Welland & Deepings
Internal Drainage Board
Deeping House
Welland Terrace
Spalding
PE11 2TD

27th February 2012

Re: Taylor Wimpey East Midlands Ltd, Wygate Park South, Spalding, Lincs
Details of Surface Water Disposal

NOTES

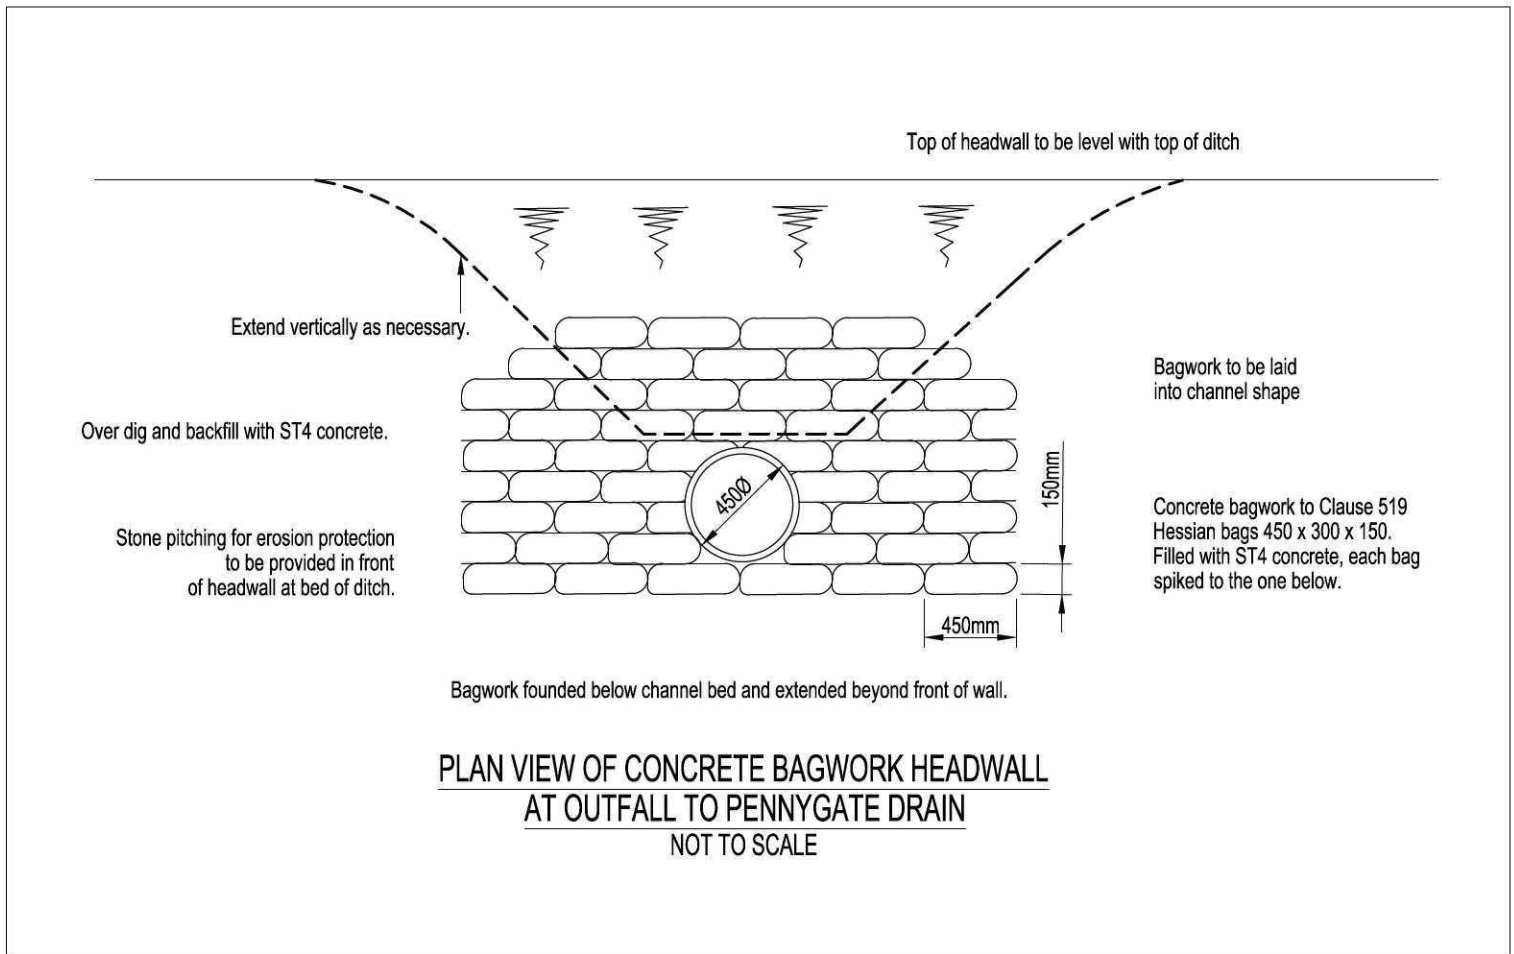
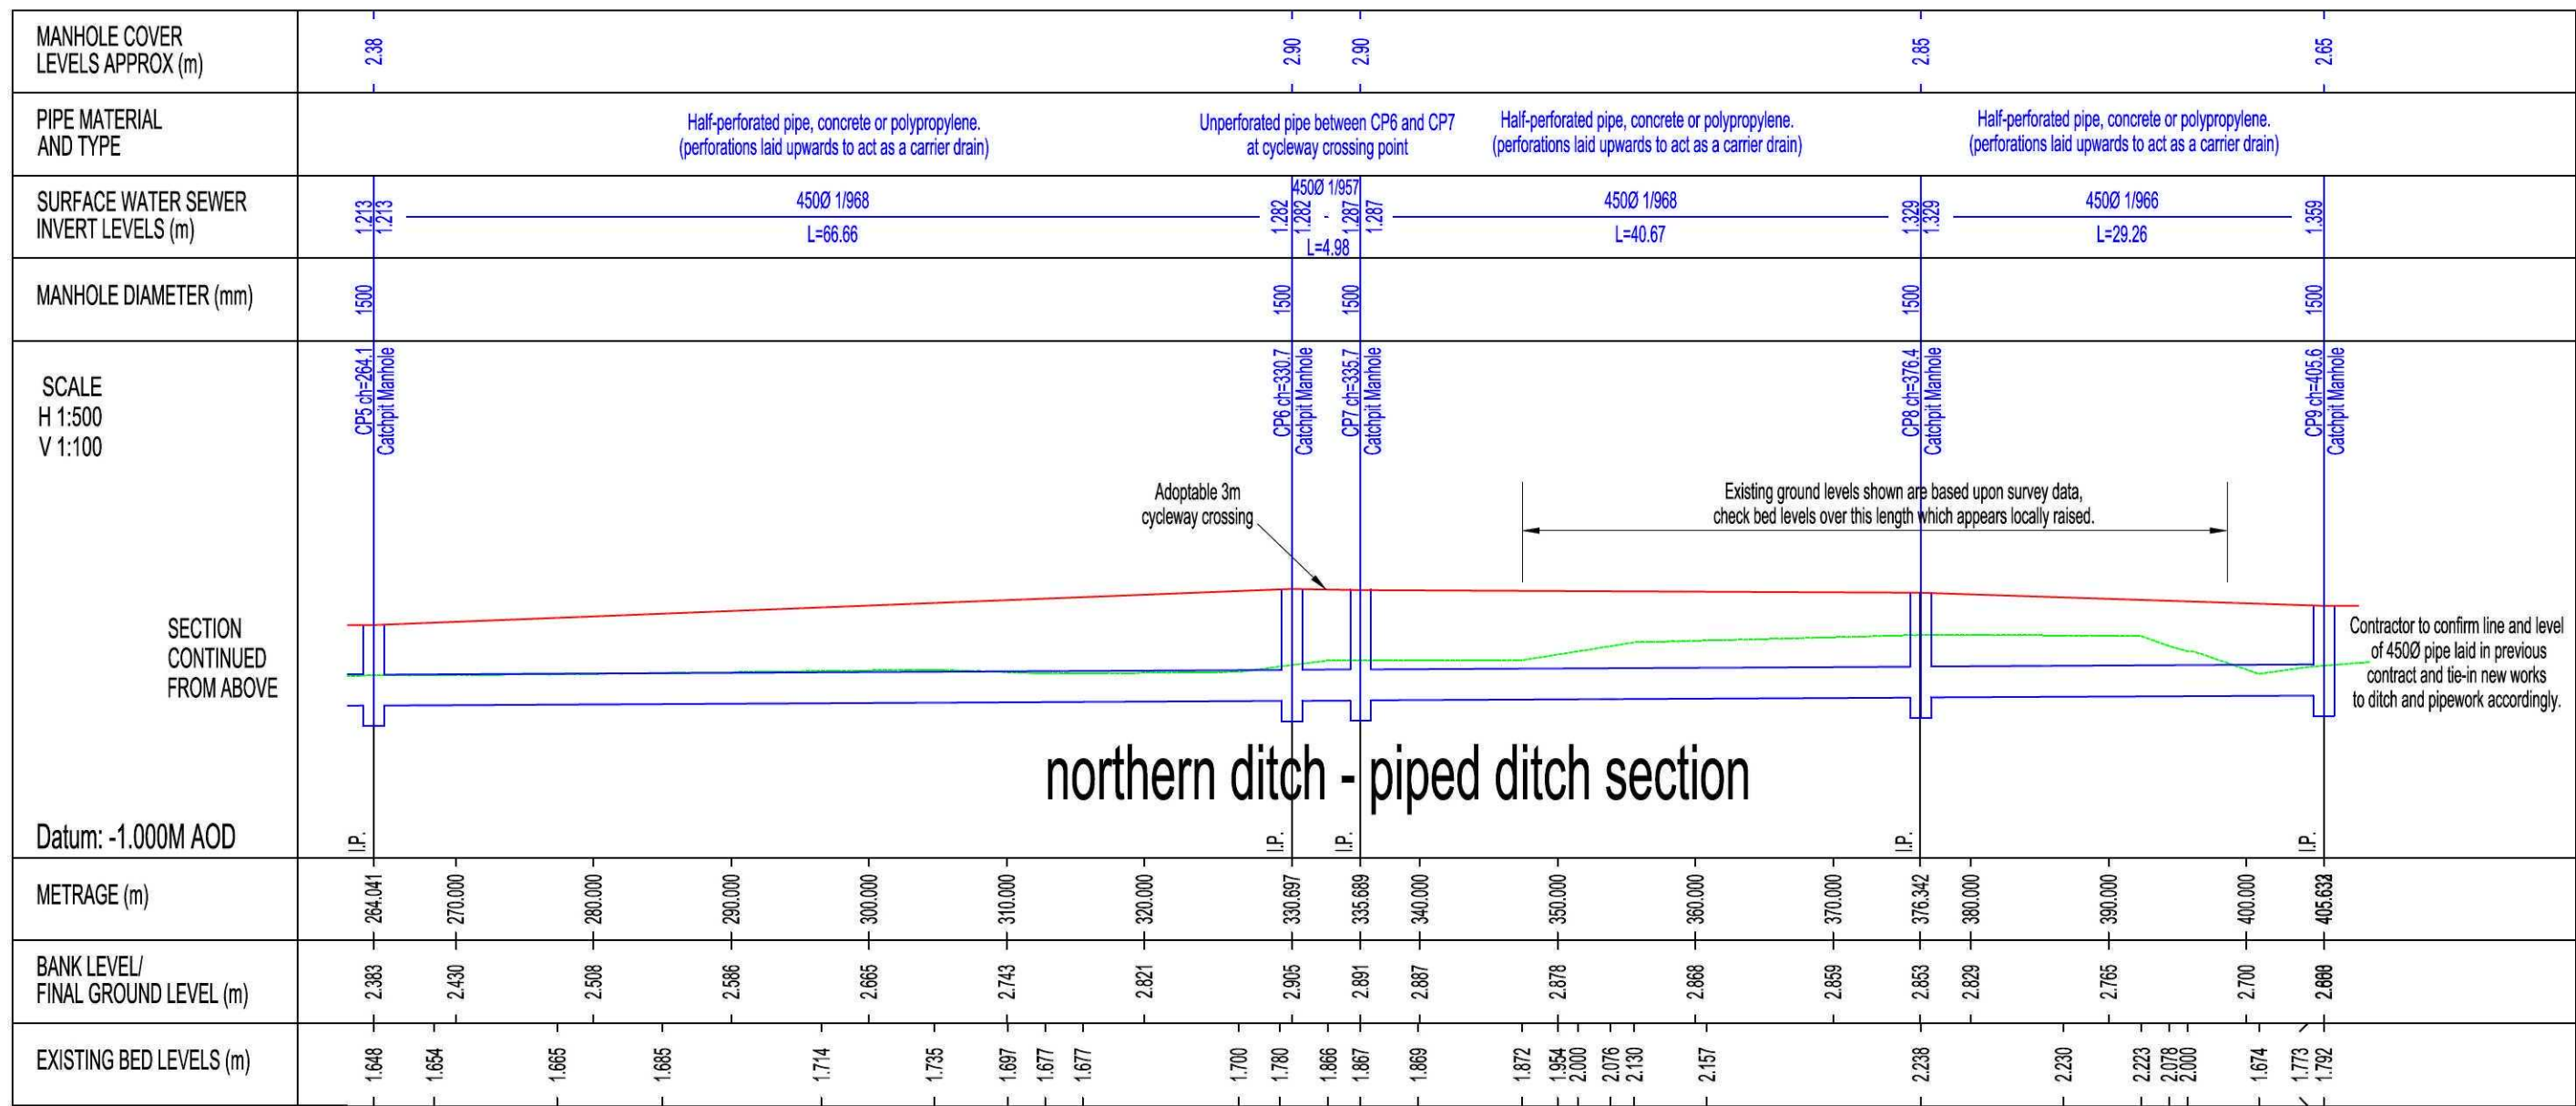
The proposed details for the culverting of the northern ditch, as shown on drawing numbered TWY014/113/A, is acceptable to the Board.
